Date: April 29 2025

File: 073124 - 45 Oak Street

URBAN DESIGN REVIEW PANEL REPORT - 45 OAK STREET

ÉÉP LOUISE-ARBOUR 45 OAK STREET, OTTAWA, ON

ROOF PLAN
1:175

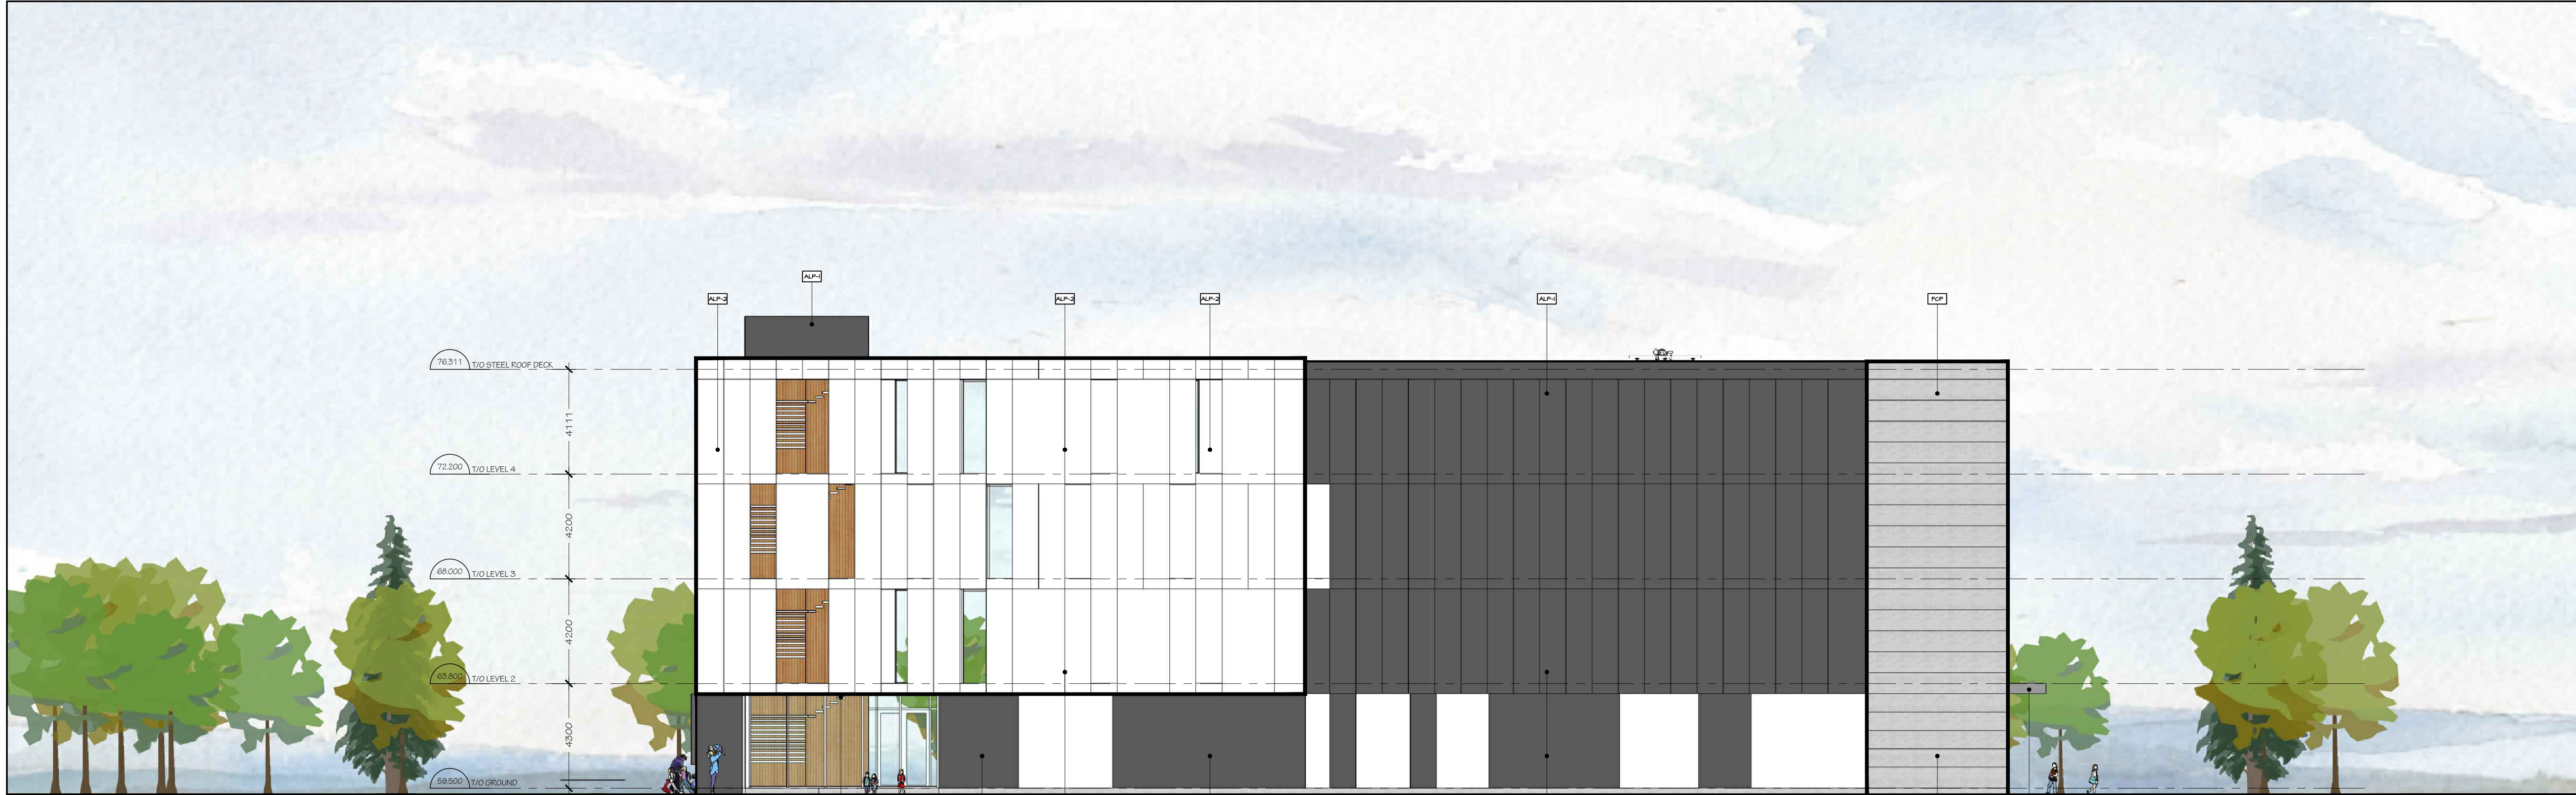
(20 of 25) The Panel appreciates the urban school typology and its potential to deliver a compact, multi-level education facility, but recommends refining the schools architectural expression to reflect its identify more clearly.

(21 of 25) The Panel suggests reconsidering the neutral architectural language of the school, proposing a more playful and colourful palette that distinguish it from adjacent residential towers.

The recommendation is appreciated and the team will review the architectural expression as the details of the design evolve through the Site Plan Control process.

The recommendation is appreciated and the team will review the architectural expression as the details of the design evolve through the Site Plan Control process.
